3 Pleasant Ave Amendment App & Fast Track

From: John Shields <jshields1@maine.rr.com>
To: "Laurie Leader" <lr@portlandmaine.gov>
Cc: "Bob Gaudreau" <Bob@hardypond.com>
Date: Mon, 23 May 2016 12:31:01 -0400
Subject: 3 Pleasant Ave - Revision No 4

DOOR SCHEDULE

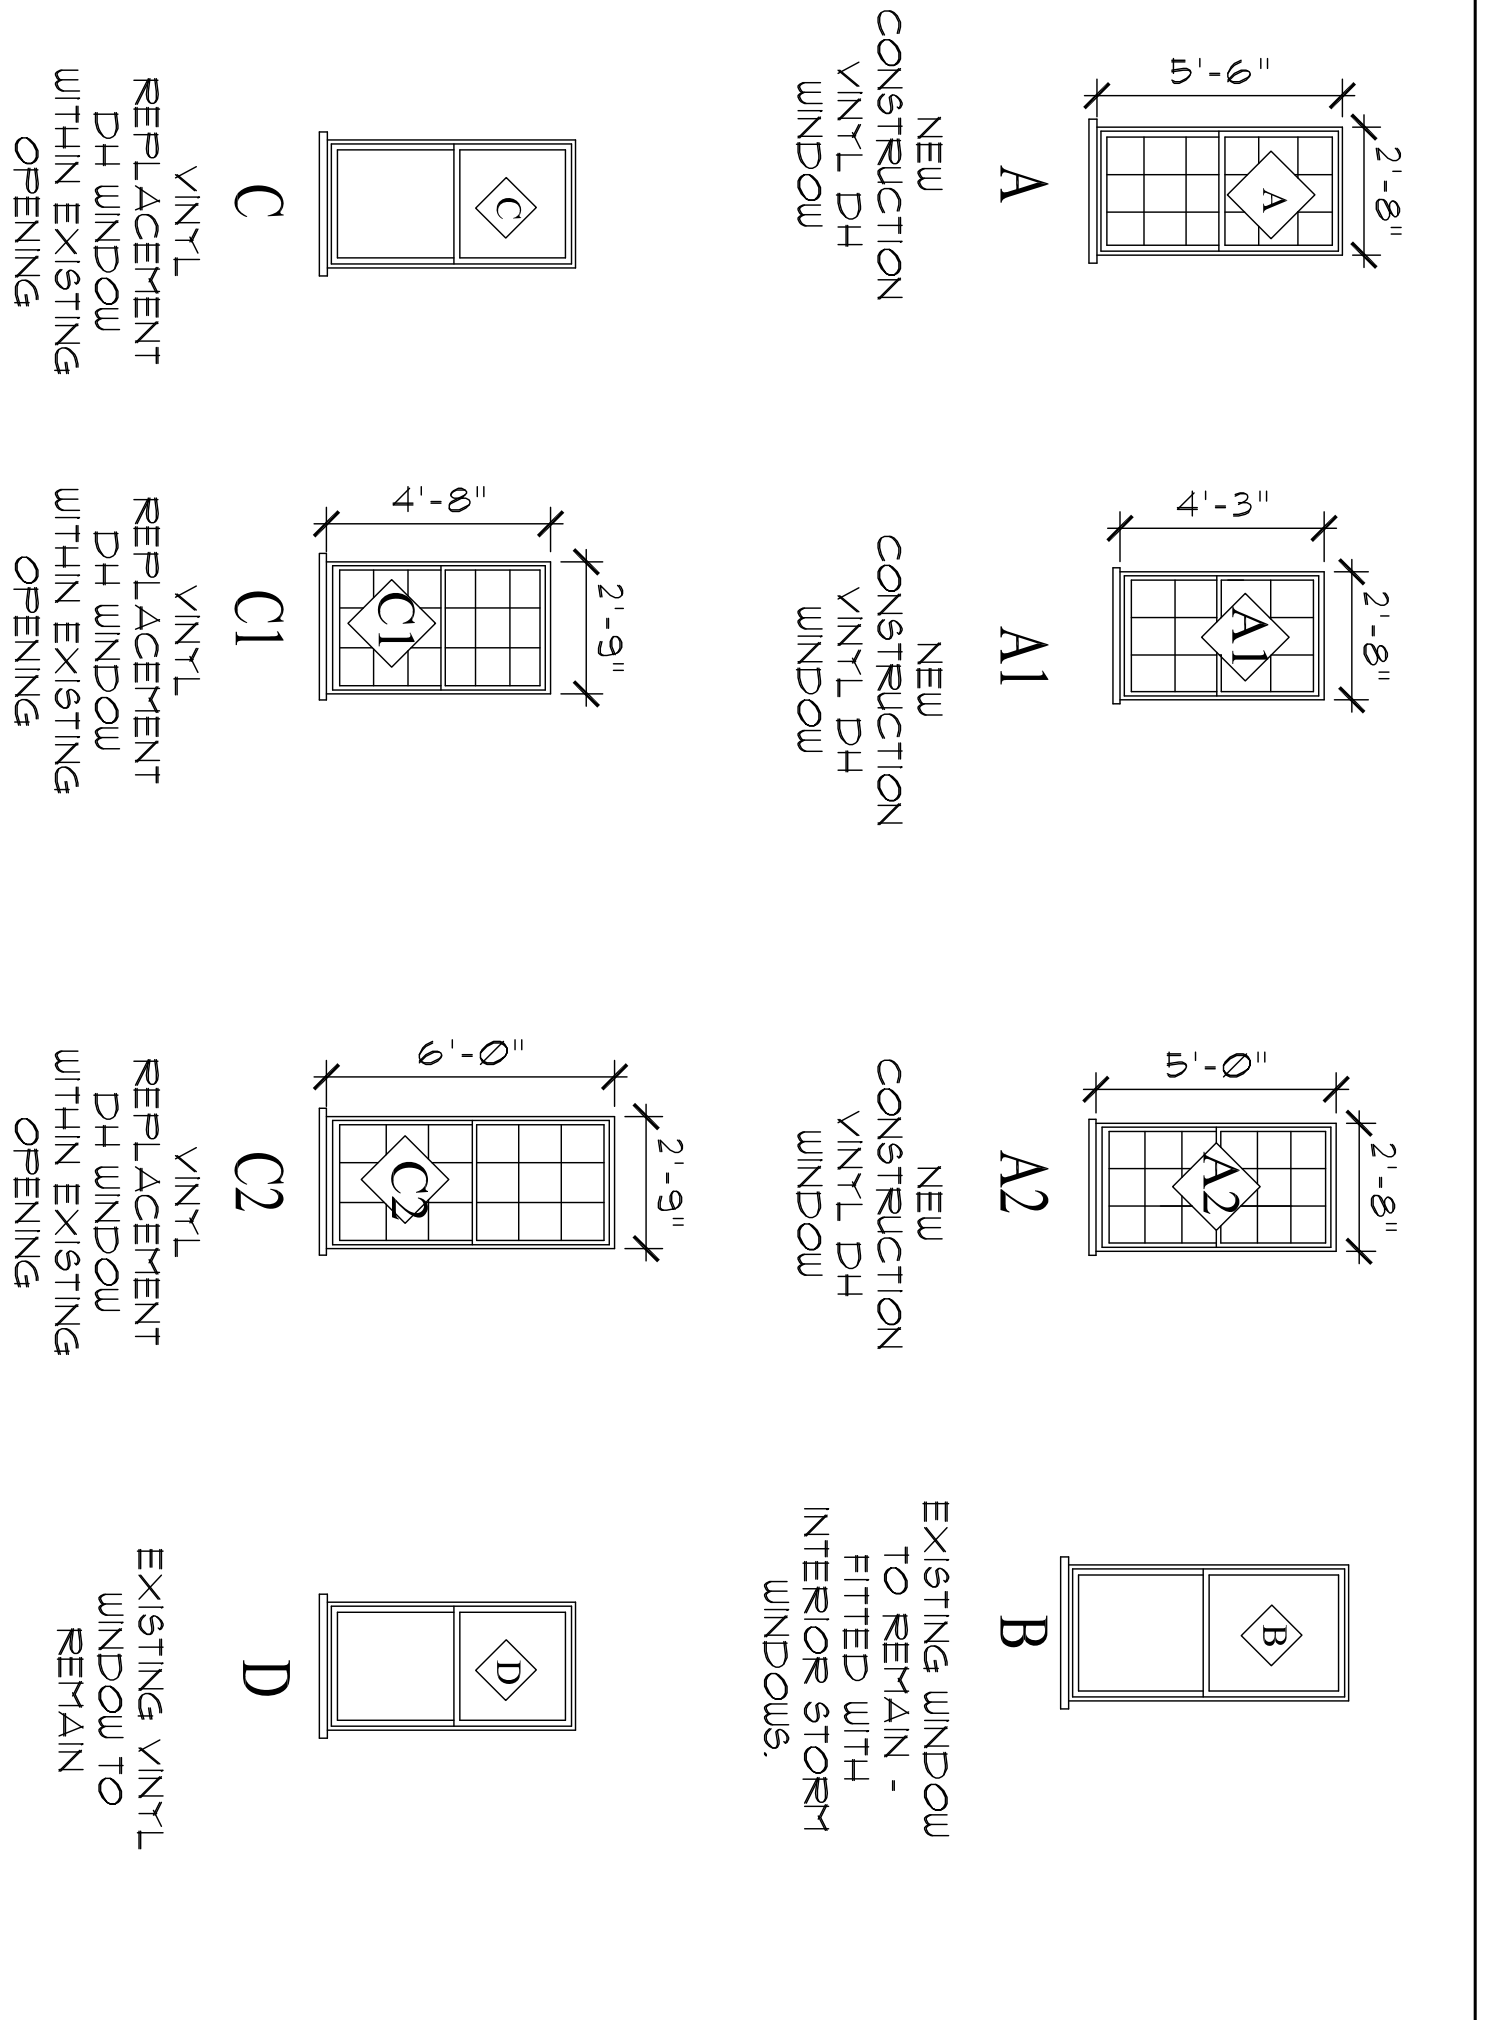
7. Drawing A-12 Schedules: Door Schedule revised.
8. Drawing A-13 Wall, Floor, Ceiling & Roof Types: Wall Type W4 Exterior Wall changed to note that exterior finish may be wood or vinyl.

TYPICAL FIRST FLOOR KITCHEN & BATHROOM PLANS
1/2" = 1'-0"

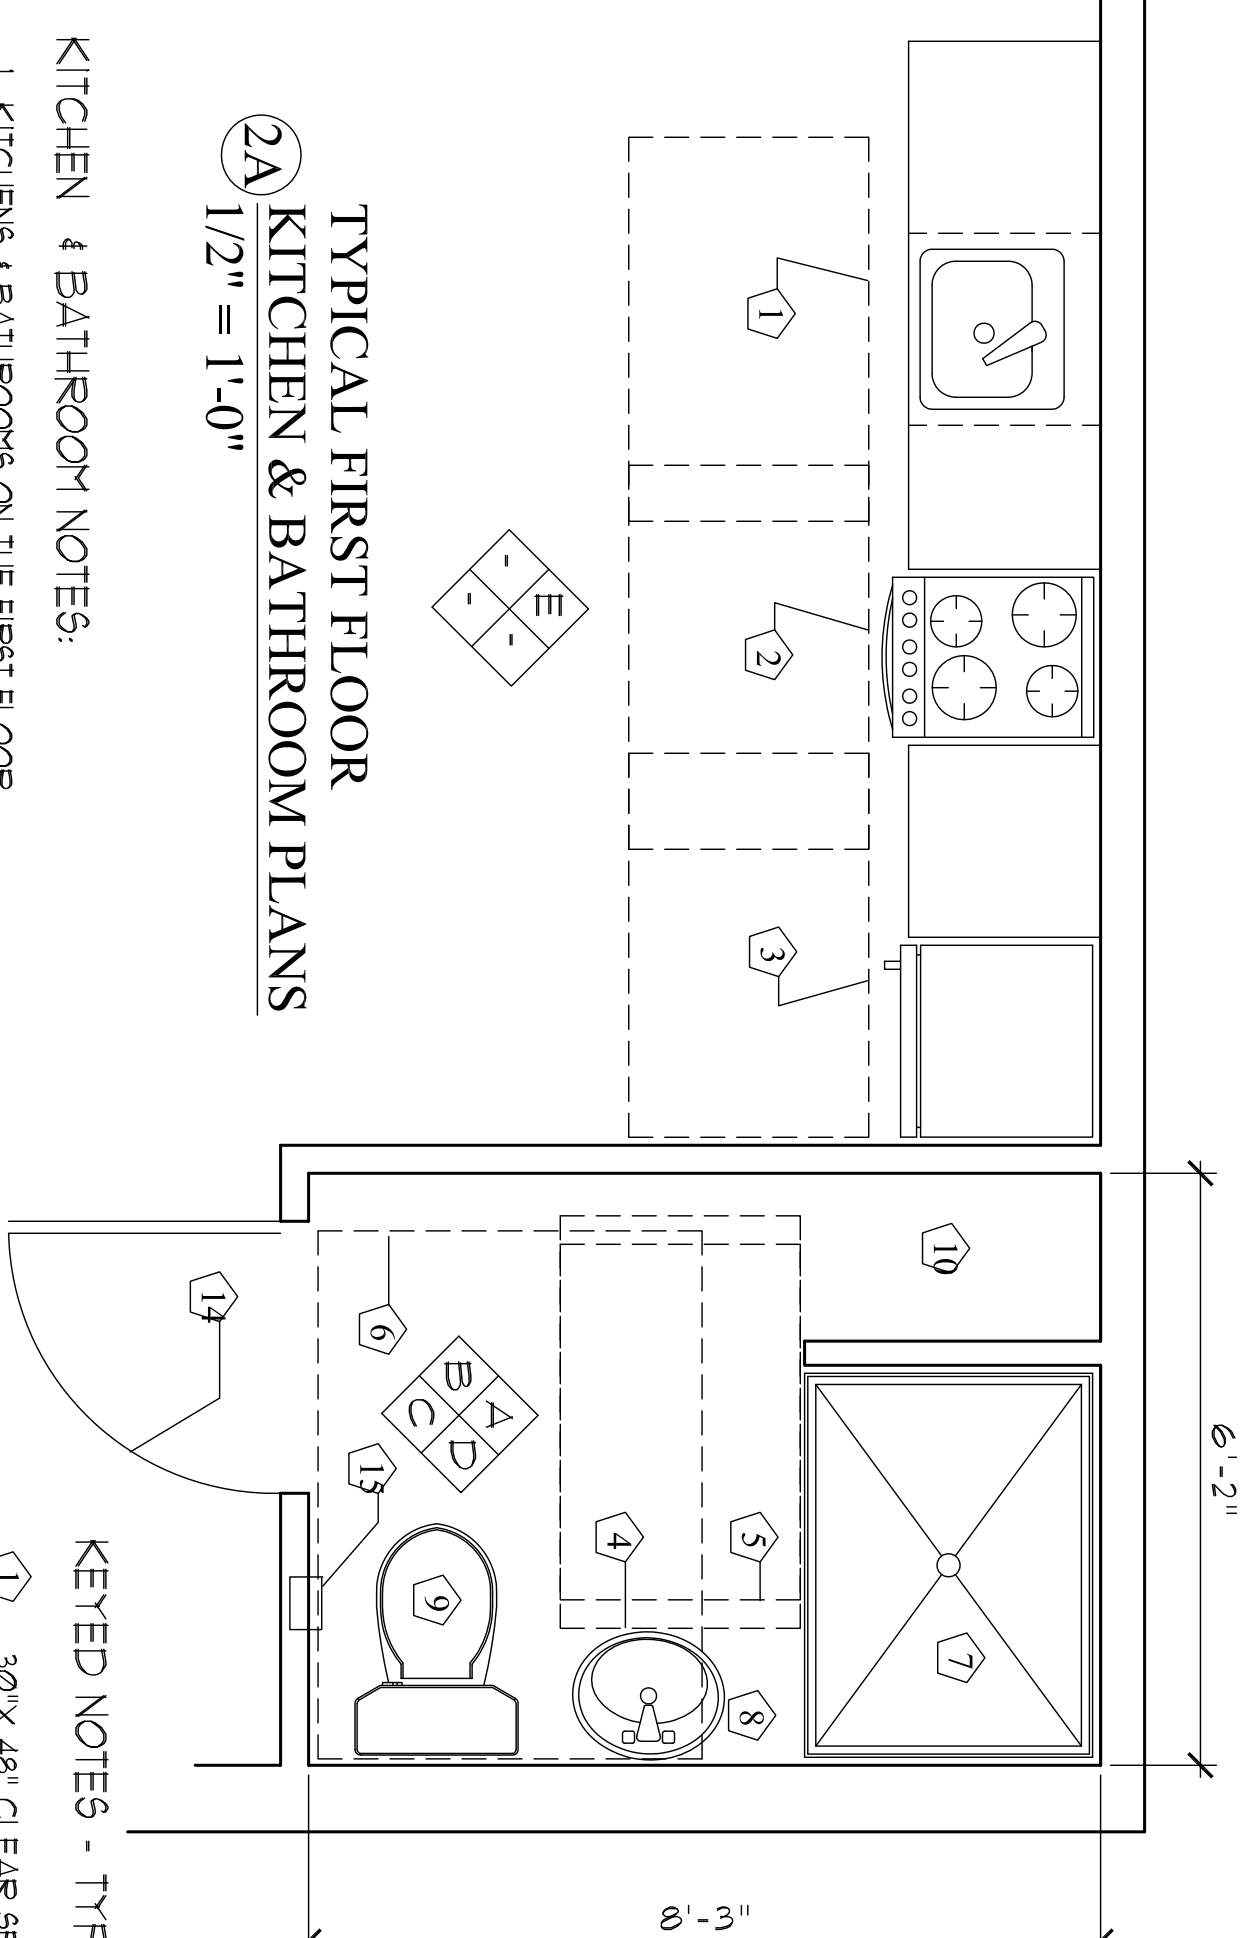
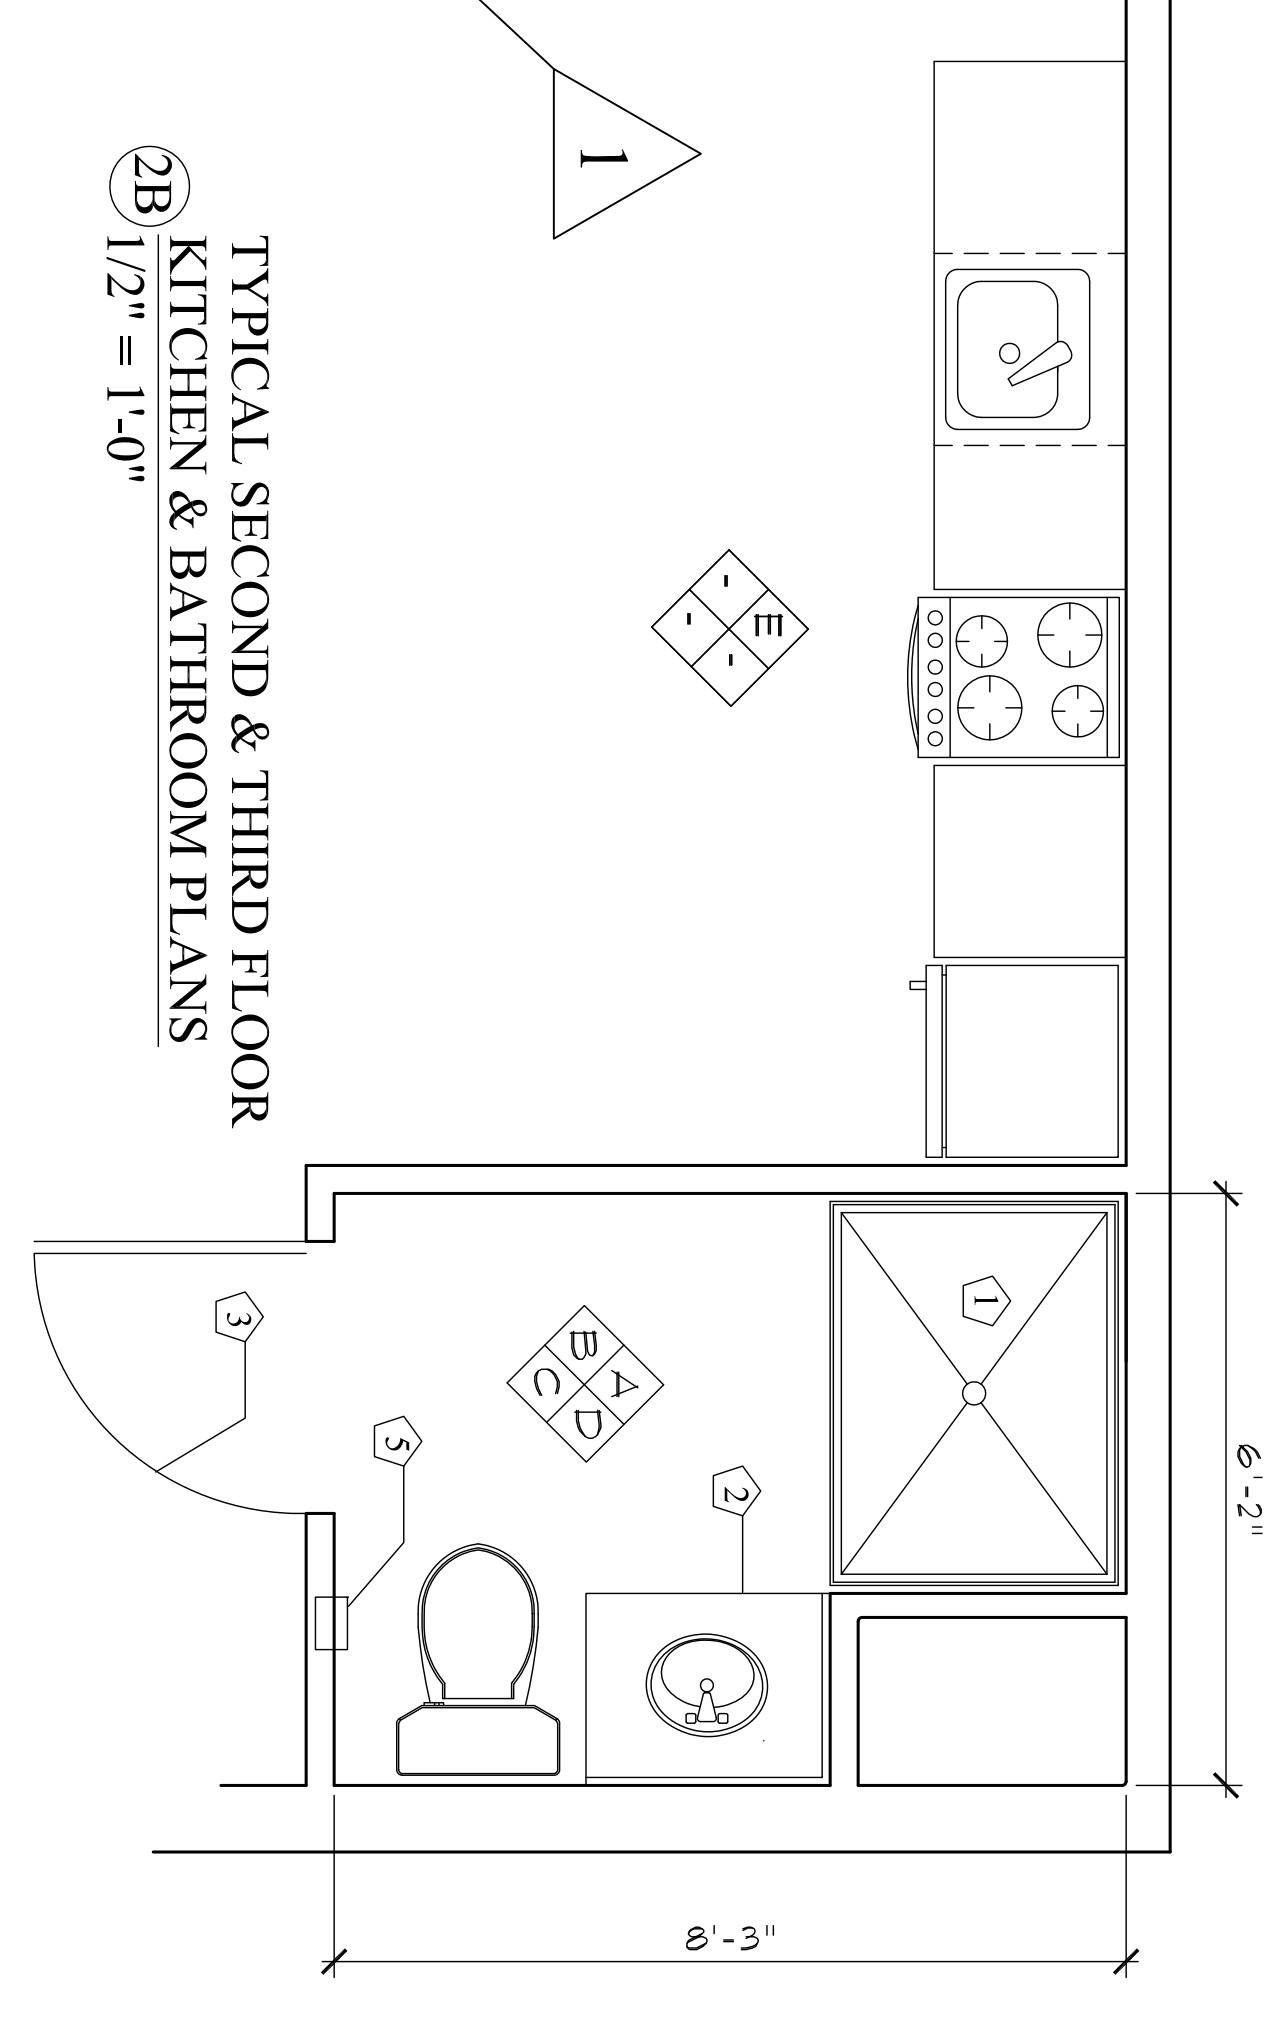
9. Drawing A-15 Details: Drawings 2A and 2B added to show pedestal type lavatories in first floor bathrooms and vanity type lavatories in second and third floor bathrooms. Vanities are preferred but the first floor units are required to be accessible per the requirements for "Type B" units of ANSI A117.1, hence the pedestal lavs.
